The Faversham Society

CHSP Examination

Submission to Issue Specific Hearing on the Development Consent Order 18 July 2019

**Indicative Electrical Compound
(Battery Pack)**
Figure 5.6d

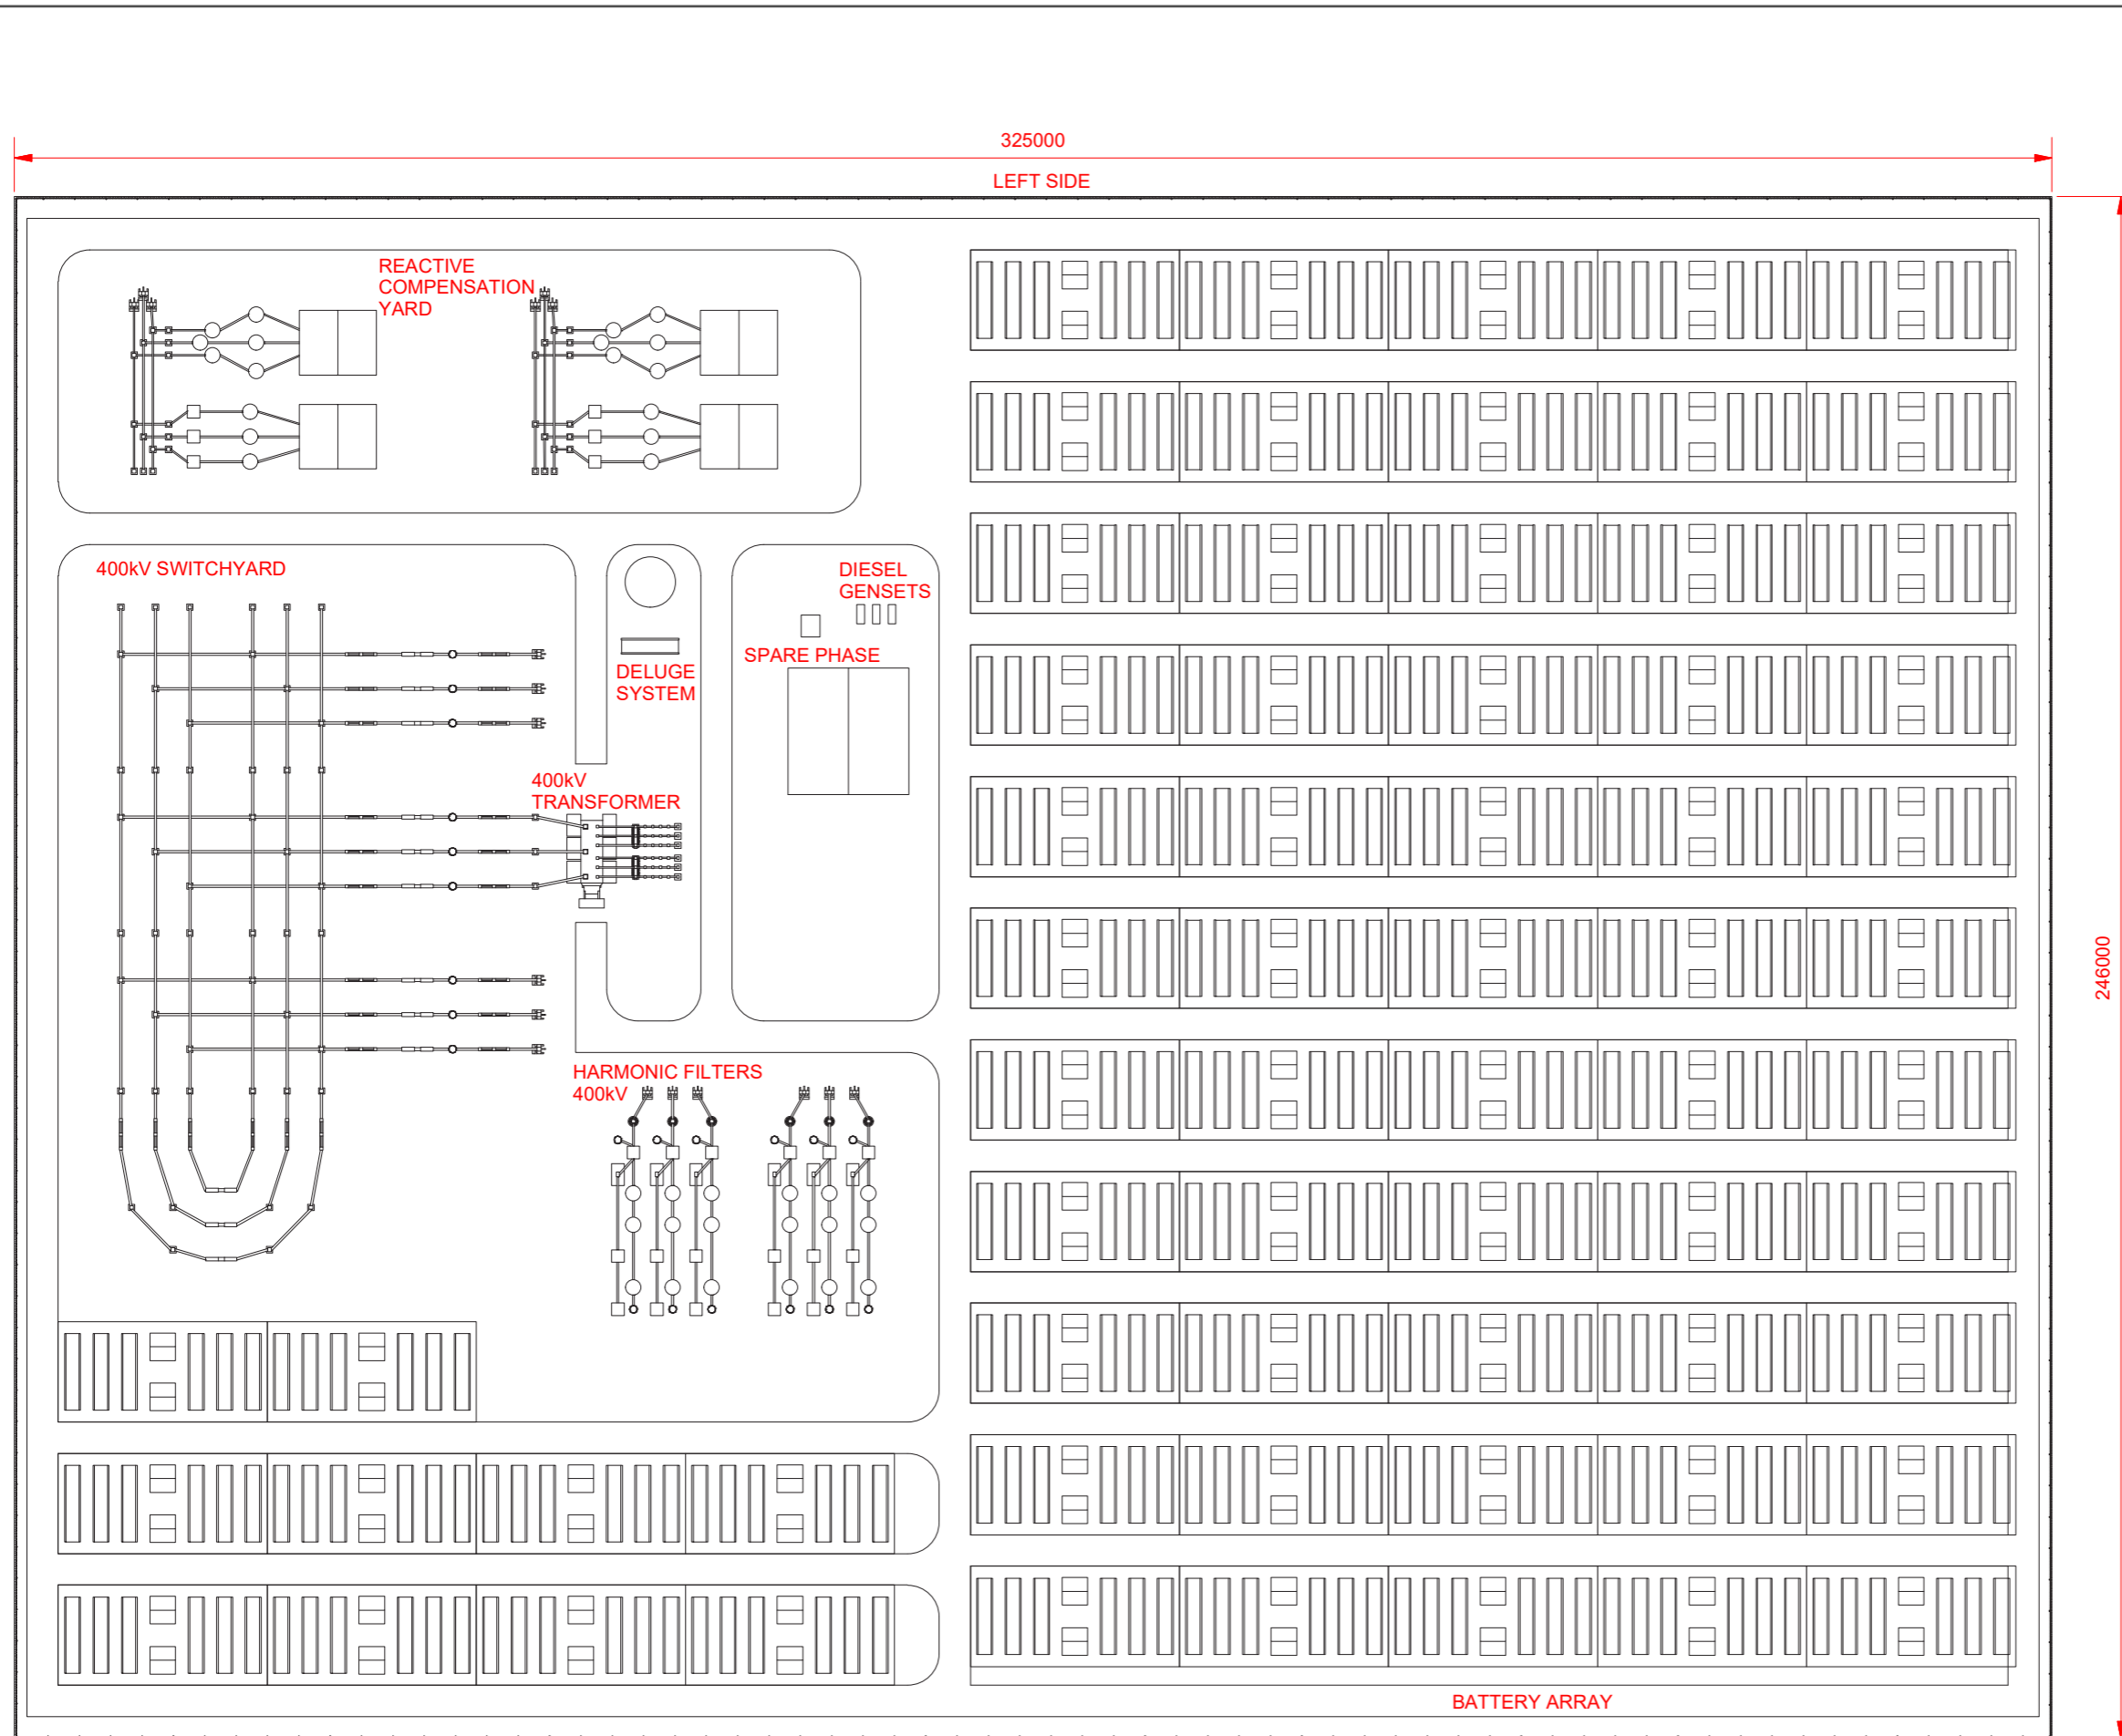
1. We have a number of concerns about the content of the DCO and about how compliance will be assured.
2. We have concerns about the limitations of the Rochdale Envelope about hazards associated with emerging battery technology. The application lacks detail on the battery technology to be installed. Li-ion batteries are potentially hazardous.

3. It is not clear from the developer's plans how the Fire Service would secure access to the battery storage area or effectively fight a fire within the compound, remembering that the compound is comparable in size to the Faversham recreation ground. We believe that the DCO should require the specification of all access routes.

6. There is no acknowledgement or proposed mitigation measures for the risk of a small fire spreading to other cells and becoming catastrophic with highly toxic emissions of Hydrogen Fluoride gas from burning Li-ion batteries in the air over Faversham or Graveney?
